TERRESTRIAL ECOLOGY ISSUES WITHIN THE RESPONSE TO SUBMISSIONS DOCUMENTATION FOR THE NARRABRI GAS PROJECT.

1. Review of biodiversity matters within Response to Submissions
2. Expert Report on adequacy of response to issues within submissions from Upper Mooki Landcare Inc

Review: Biodiversity issues within the Response to Submissions documentation for the Narrabri Gas Project.

Figure 5: Overall site value in rehabilitation areas compared to nearby reference sites not disturbed by the project (2013-14)

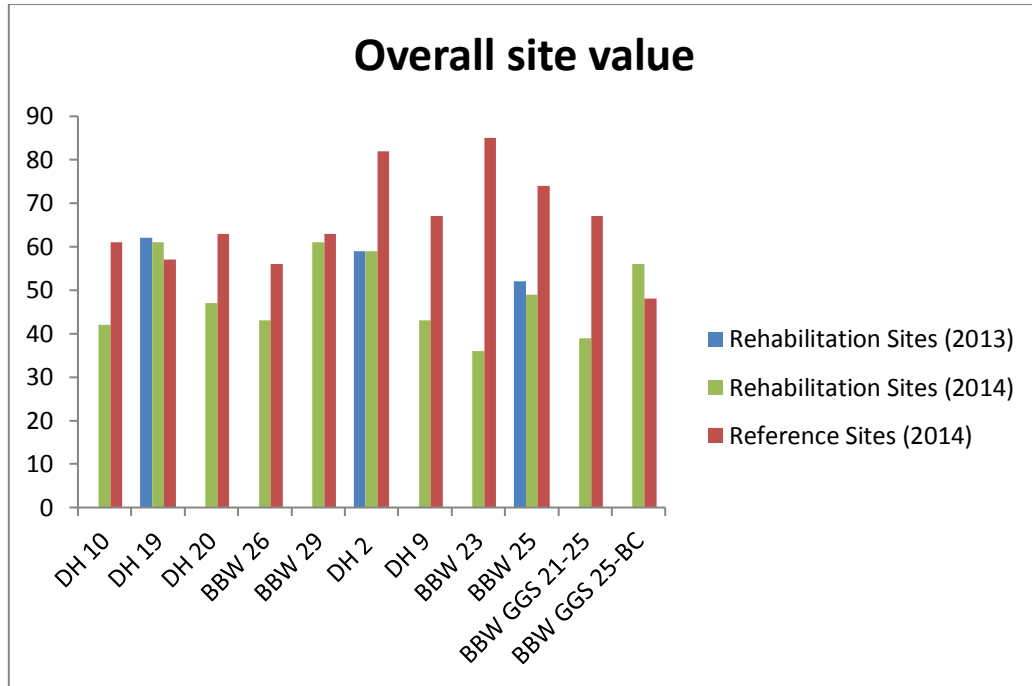
21. However, the quantum of credits being claimed for rehabilitation sites by Santos is based on the assertion that sites currently show a similarity of 74% to the natural benchmark conditions and are on a trajectory for becoming natural communities. Santos provide no verifiable data to support their claim in the Rehabilitation Plan (Appendix V of EIS) or in the RtS other than Figure 5 of the Plan which shows differences in 'site quality' for a number of sites. How this indice was calculated is not clear. Site inspections of well sites in PEL238 undertaken independently (Pilliga Environment Group 2018) show that species diversity on the whole is low compared to biometric benchmarks, as is vegetation cover, particularly at ground-storey and understorey layers. Weeds at well sites are also common but absent from nearby bushland and soil conditions at well sites are sub-optimal for the growth of native vegetation. See review of rehabilitation section below.

29. Santos have repeatedly stated that current rehabilitation is on track to meeting **completion targets**, in terms of species composition and vegetation structure at the sites, for example: *“Rehabilitation to date shows similar numbers of native species to reference sites, is dense shrub layer, relatively low weed cover and regeneration of overstorey through coppice regrowth.”* These and other statements have been examined in the attached independent study of the soil and vegetation conditions currently found at existing well sites in PEL238 (Pilliga Environment Group 2018).

35. The claim by Santos that they have achieved success at some sites because of coppiced growth is also very misleading because at most sites all stumps have been removed and so cannot be used as a standard approach for overstorey generation. Use of canopy species as indicators of success should always include the presence of all canopy dominants, including White and Black Cypress Pine and Bull Oak when present at reference sites. These species are conspicuously absent from current rehabilitation sites.
